Town & Country Planning Act 1990 (as amended)
Town and Country Planning (Development Management Procedure) (England) Order 2015
Application for approval of details reserved by condition imposed on planning reference
WA/22/15/OUT (following appeal) relating to condition 7 - Design Code
Land to the East of Fontwell Avenue Fontwell Avenue Fontwell

Arun District Council have decided to **REFUSE details reserved by condition for the following reasons:**

3 Character Areas

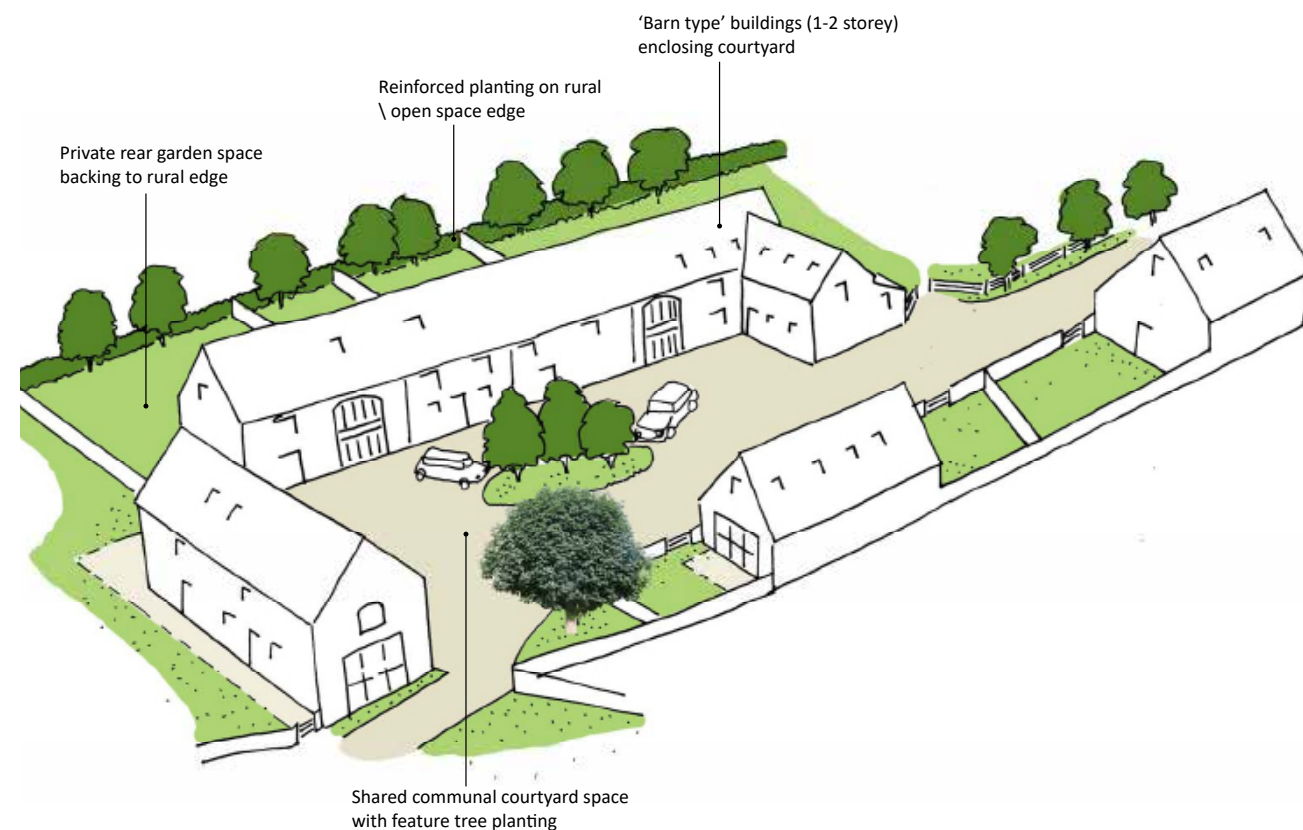
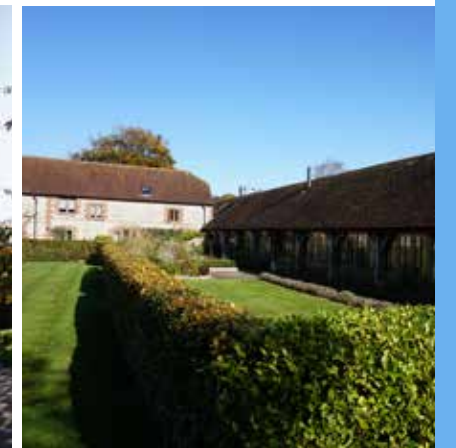
The submitted Design Code Masterplan contains relevant built character reference images from settlements within the Coastal Plains Landscape Character Area and the adjoining Sussex Downs Landscape Character Area. However, the document does not contain clear guidance on the architectural features that are to be carried forward to give the housing in each of the five framework character areas an attractive and distinct identity. There is a particular lack of guidance on facade design, such as the degree of symmetry, variety, the pattern and proportion of windows and doors and their details. The submitted Design Code Masterplan does not therefore accord with Policies D SP1 and D DM1 of the Arun Local Plan 2011-2031 or with the National Design Guide 2019.
